**WEST SUSSEX COUNTY COUNCIL
STRATEGIC PLANNING CONSULTATION**

SUBJECT: LU/13/15 - Demolition of original dairy distribution depot and construction of 8No. dwellings and ancillary works. Resubmission following LU/298/13. This application may affect the Character and Appearance of the Littlehampton (East Street) Conservation Area.

The Old Dairy behind, 3 & 5, Church Street, Littlehampton, BN17 5EL

SUBJECT: LU/177/14/PL - Demolition of original dairy distribution depot and construction of 8No. dwellings and ancillary works. Resubmission following LU/298/13. This application may affect the Character and Appearance of the Littlehampton (East Street) Conservation Area.

Pedestrian visibility from the west

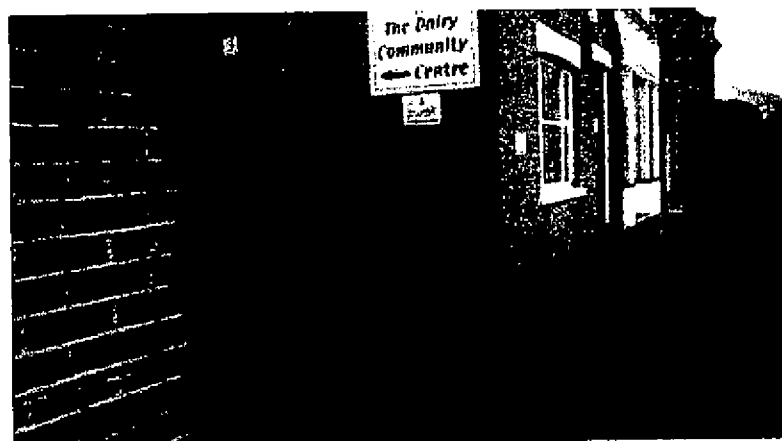
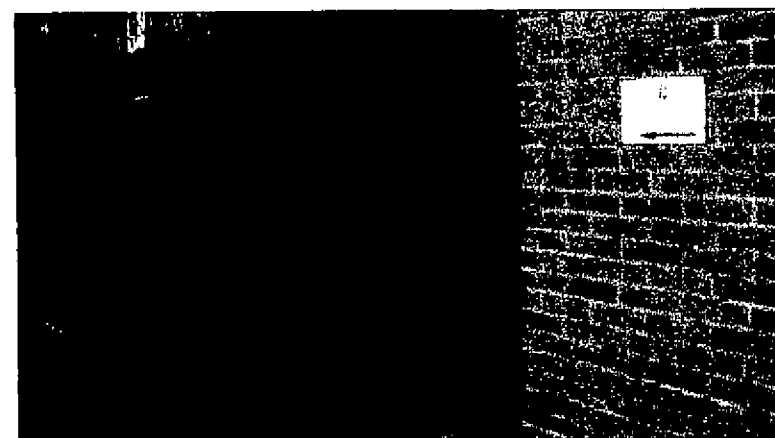
The first problem identified that pedestrian visibility is restricted at the access by no 3 Church Street to the east; and a boundary wall hedge to the west. This could result in collisions where pedestrians and vehicles do not have sufficient warning of each other's presence. The auditor recommended that visibility needed to be increased. The Designer recognised this is a historic access, vehicles approached the junction slowly and the traffic generated by this development is less than the lawful use. It is also not possible to increase pedestrian visibility, although the hedge to the west could be trimmed. WSCC agree with the designer's response, to mitigate the impact by asking

for a maintenance regime to be implemented to keep the hedge trimmed on a yearly basis to improve visibility, albeit very slight.

TITLE
Fire Tender accessing the site, turning and egressing

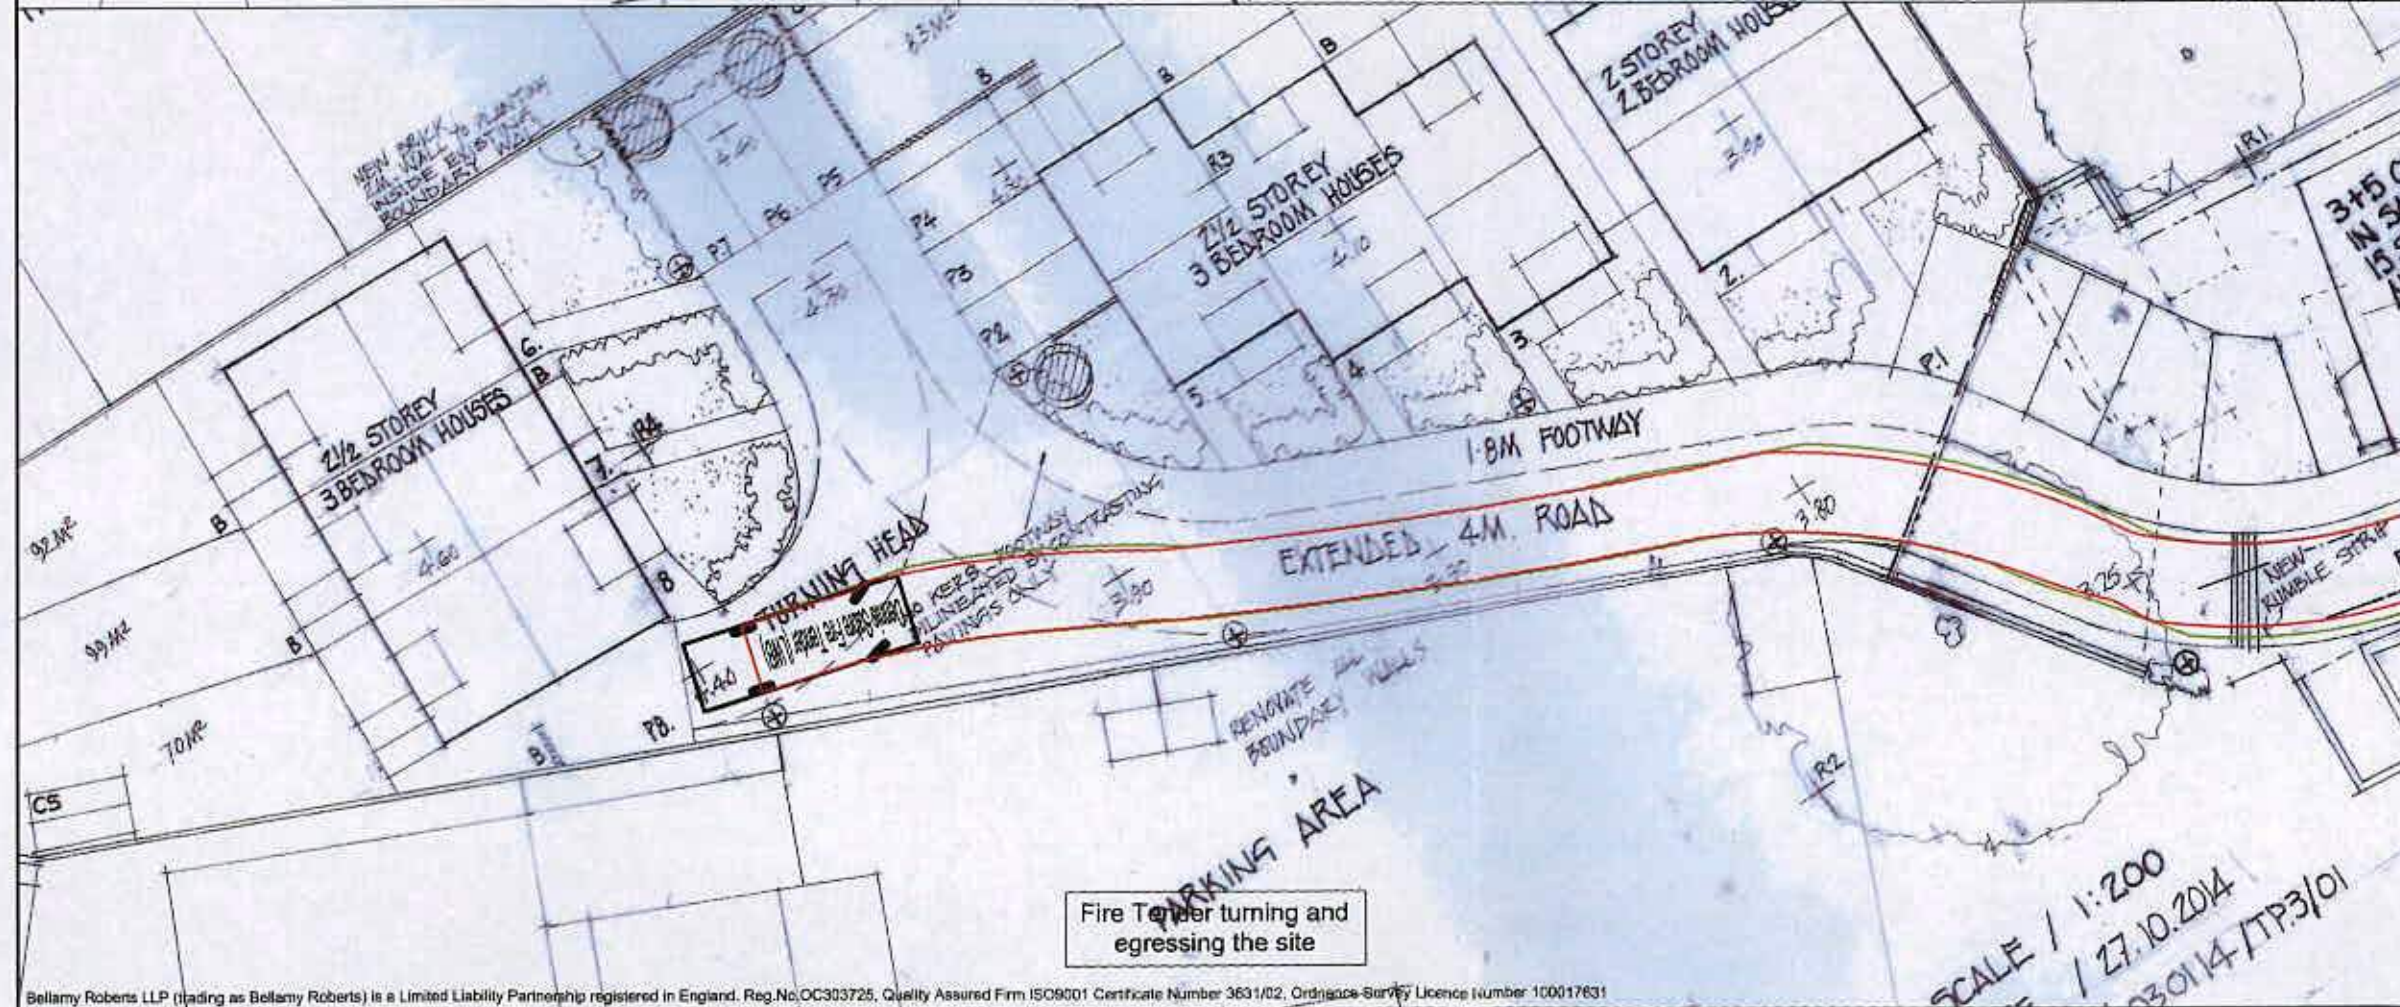
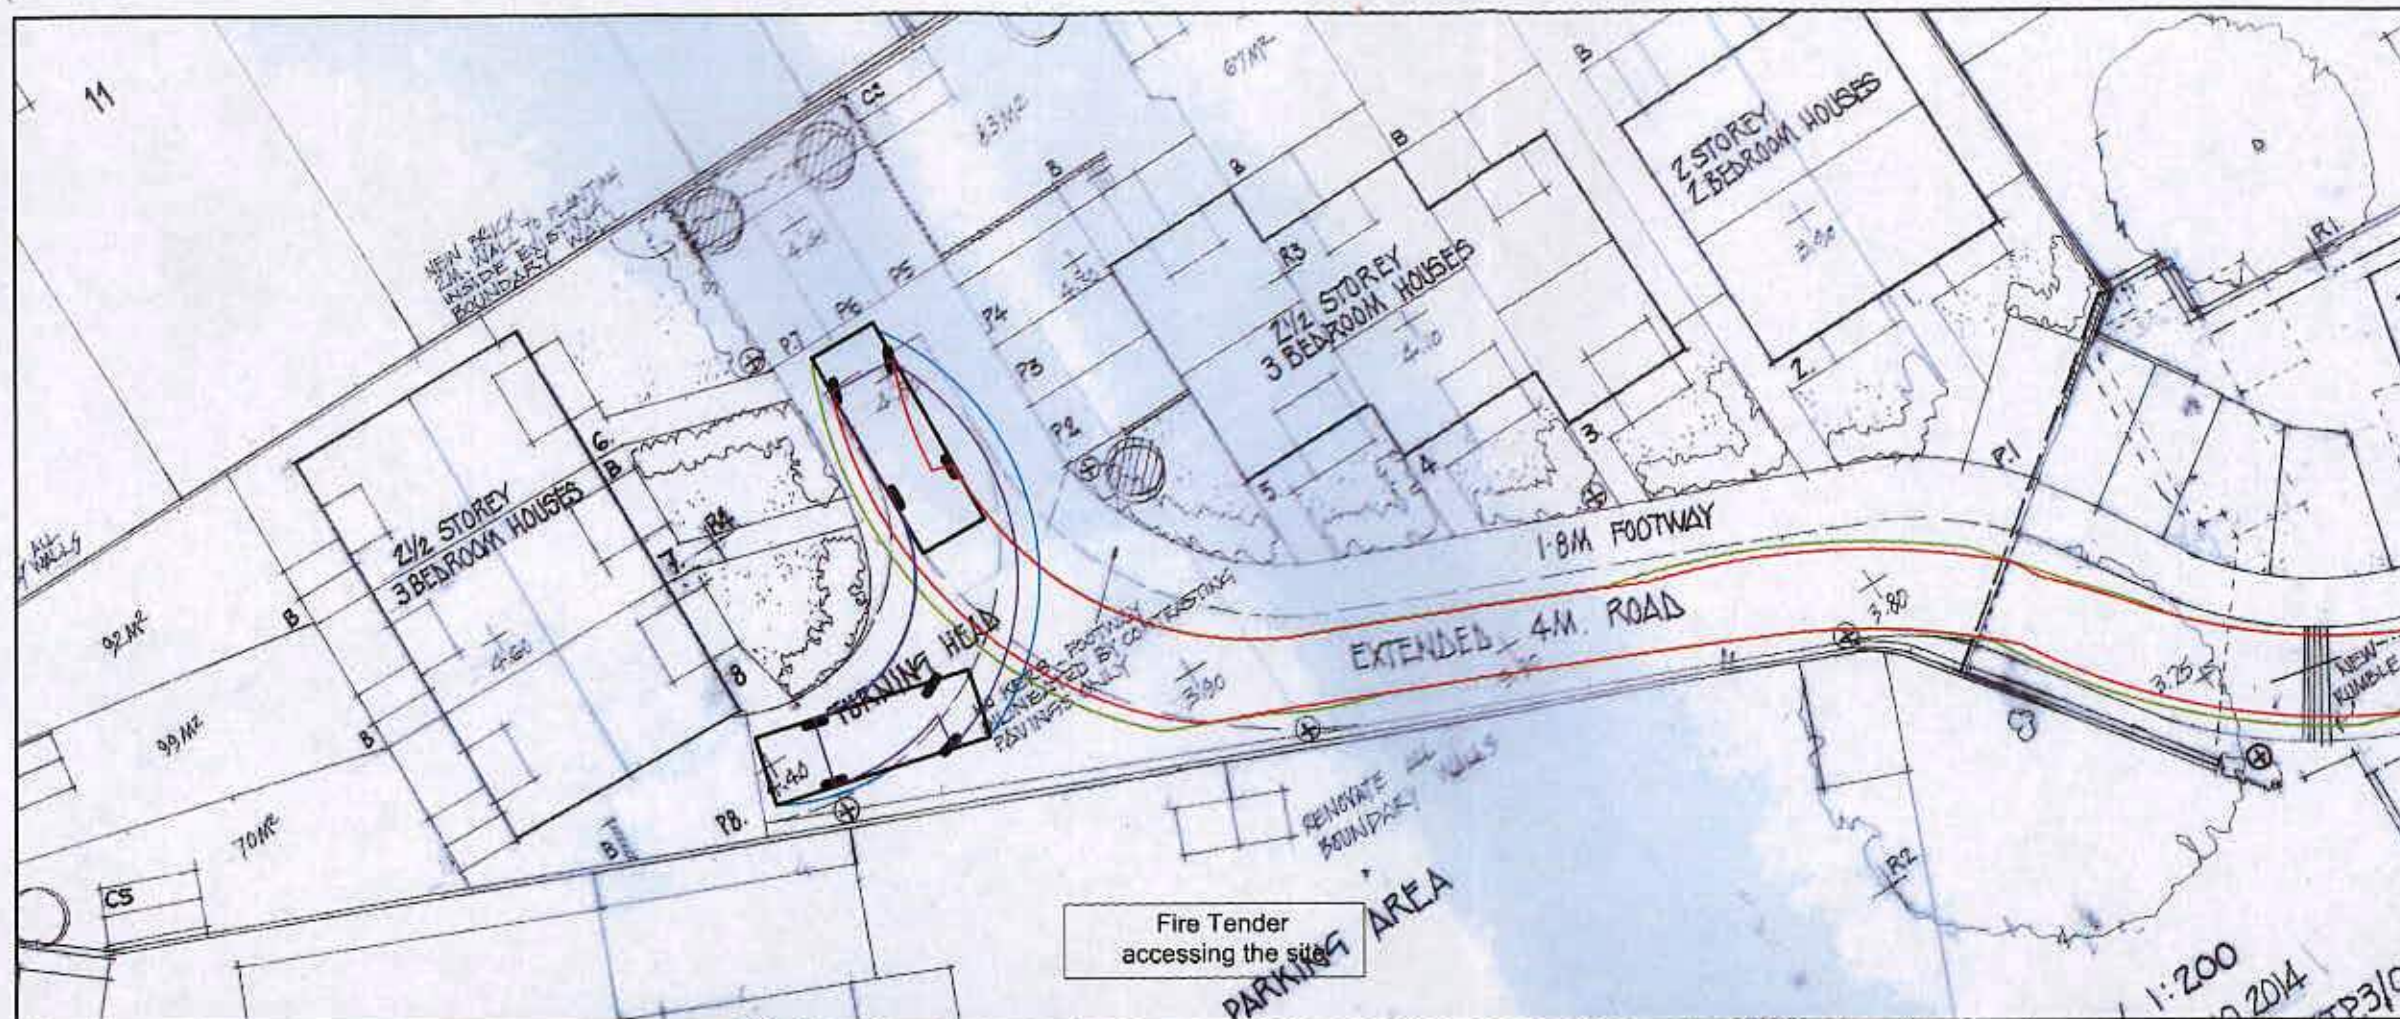
4. Internal Layout – the 4m wide carriage way looks narrow and the indication that a footway will be introduced narrows this even further. The junction radii seem tight to the extent that a refuse or emergency vehicle may not be able to turn into the site without overriding footways. The existing road layout seems short and servicing could possibly be carried out on the Church Road without the need to enter the site, which is different to the proposed. There is no connectivity between the existing footway along Church Street and the footways from the site. A shared use layout would allow for a wider carriageway width to allow for the passing of cars, without having to mount the footway. It is unclear if plots 3 & 5 will have their own driveway access onto Church Street.

Title: Refuse Collection Vehicle accessing the site, turning and egressing

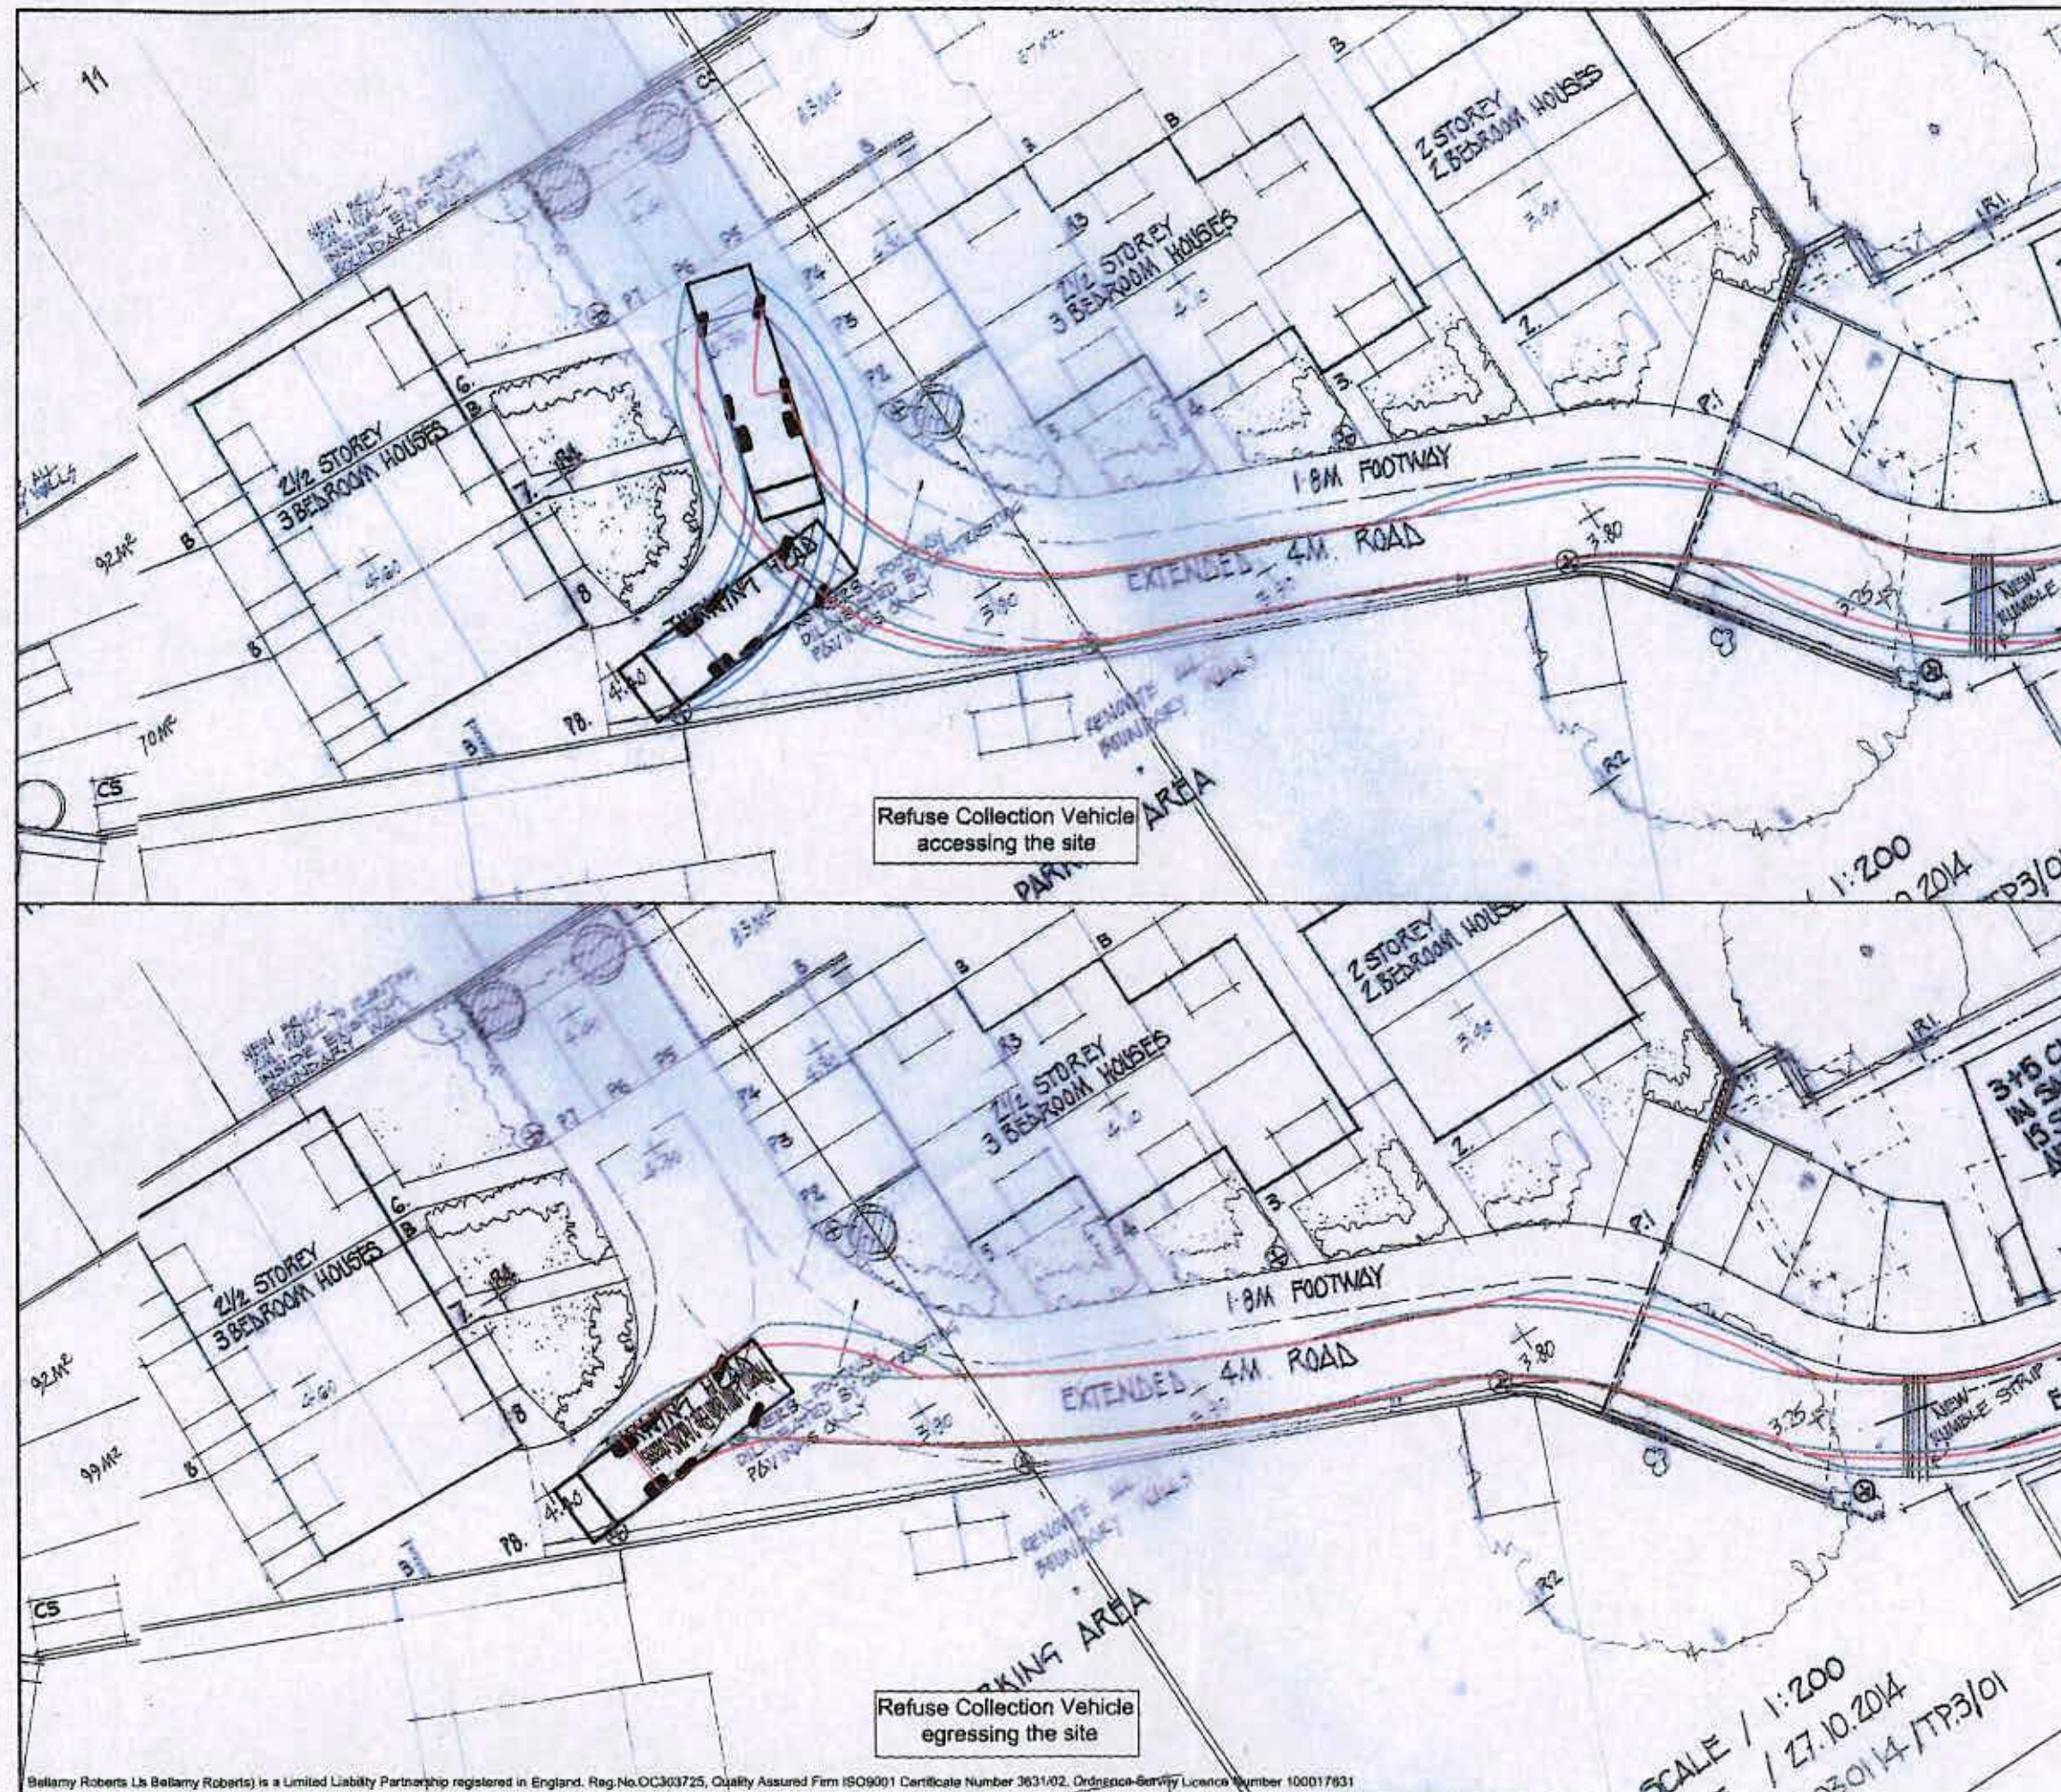
1. Swept paths for a refuse vehicle. The turn into and out of the access has not been shown in the swept path drawings submitted. We need to know that large vehicles can turn into the access safely from Church Street. If they can't alternative methods for refuse collection will need to be discussed with the local waste authority. MfS recommendations regarding waste collection vehicles should be considered. A minimum street width of 5m is recommended. Cul-de-sacs should be no longer than 20m, and a maximum reversing length of 12m. Waste collection vehicles should also be able to gain access within 25m of the waste storage point.

This planning application has responded to all outstanding issues relating to planning application LU/177/14 including swept paths, and the need for a planning obligation to fund a future TRO, which might be needed to keep the access clear and free from parked cars. The issue of the height of the existing hedge at No3 Church Street is being negotiated with the applicant to ensure the future visibility of the access is not compromised.
